Please upload the below to the above application; Highways comments.

Project:-	Proposed Residential Development 15-17 Kew Gardens Bognor Regis West Sussex		
Title:-	Proposed Visibility Plan		
Client:-	Imperial Homes (Southern) Ltd		
Scale:-	1:100 (@A1)		
Drawn By:-	PJD	Checked By:-	
Date:-	09/01/20	Date:-	
Job.No:-	180037	Drg.No:-	15

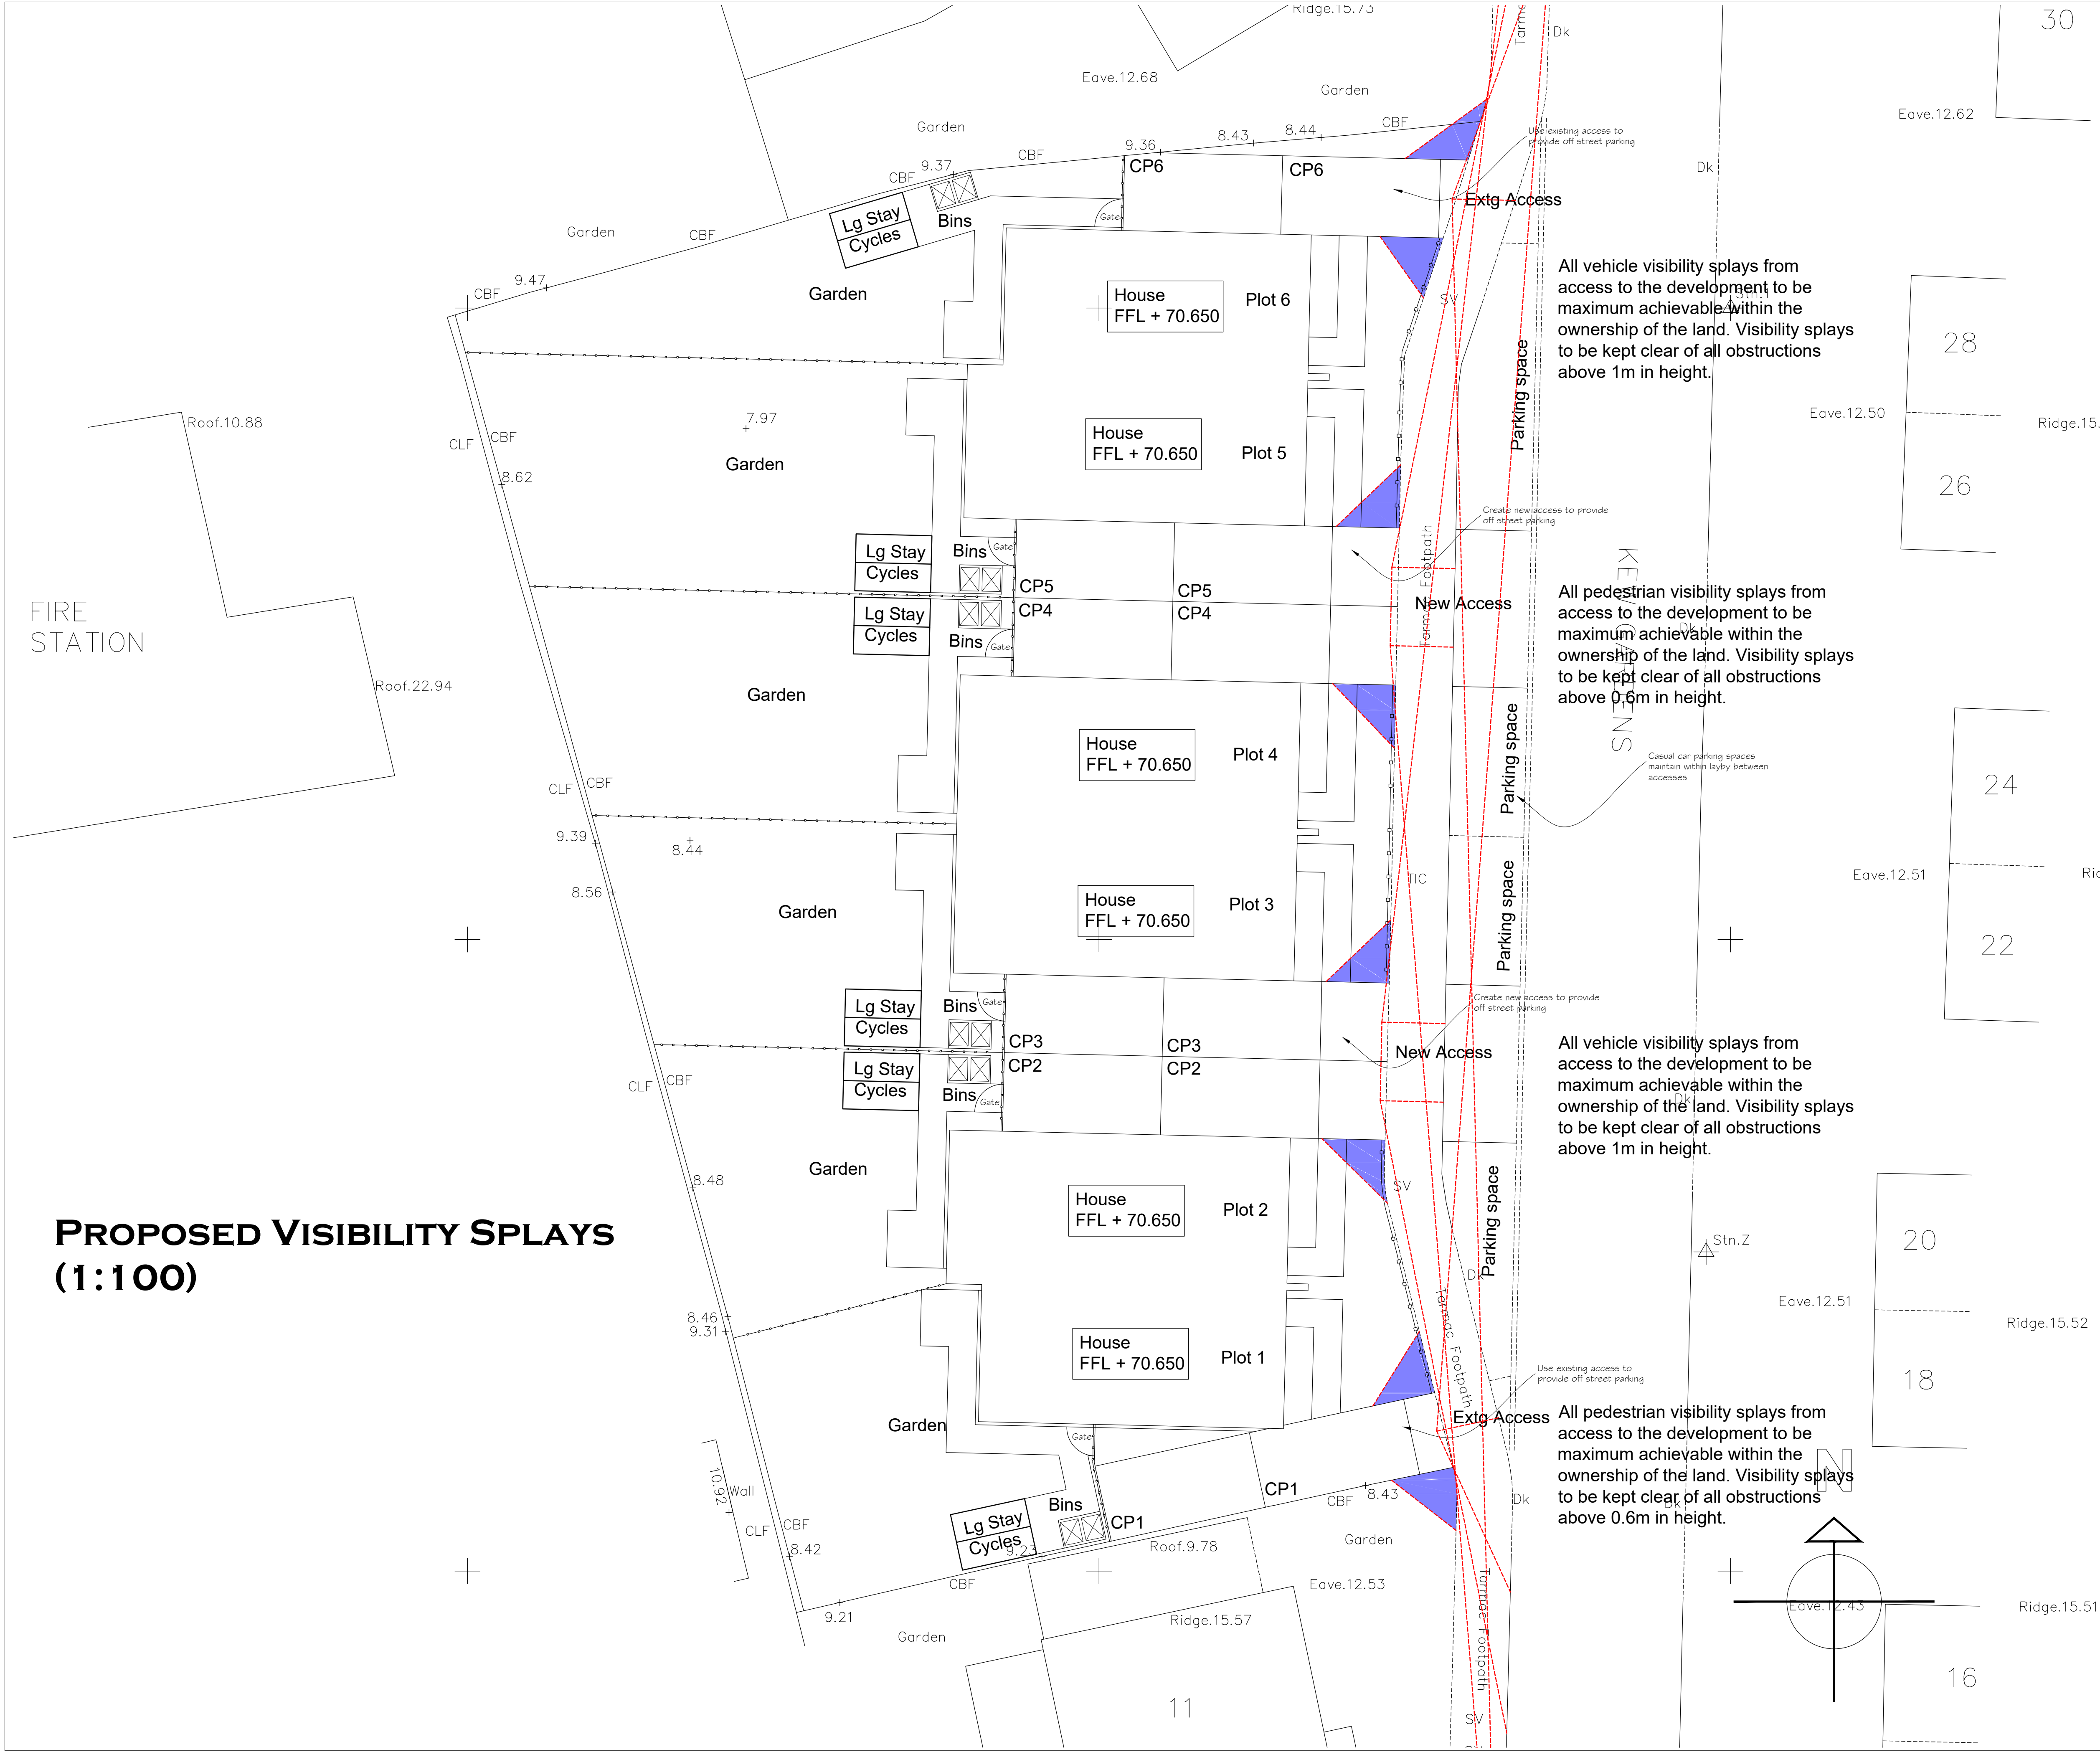
- show full extent of maximum achievable splays for new access points and annotate these.

- make red edge of site clear on the visibility plans and omit pedestrian visibility splays where these are outside of red edge

Maximum achievable vehicular visibility splays have now been demonstrated from each access point to the public highway. Whilst some of these splays pass through lay-by Manual for Streets 2 paragraph 10.7.1 states that "Parking in visibility splays in built-up areas is quite common, yet it does not appear to create significant problems in practice. Ideally, defined parking bays should be provided outside the visibility splay. However, in some circumstances, where speeds are low, some encroachment may be acceptable". The LHA consider that Kew Gardens is low speed and lightly trafficked and therefore the splays demonstrated are acceptable and plans and details pertaining to condition 15 are acceptable.

The extent of pedestrian visibility splays within red edge of site have now been made clear. The plans and details pertaining to condition 16 are acceptable.
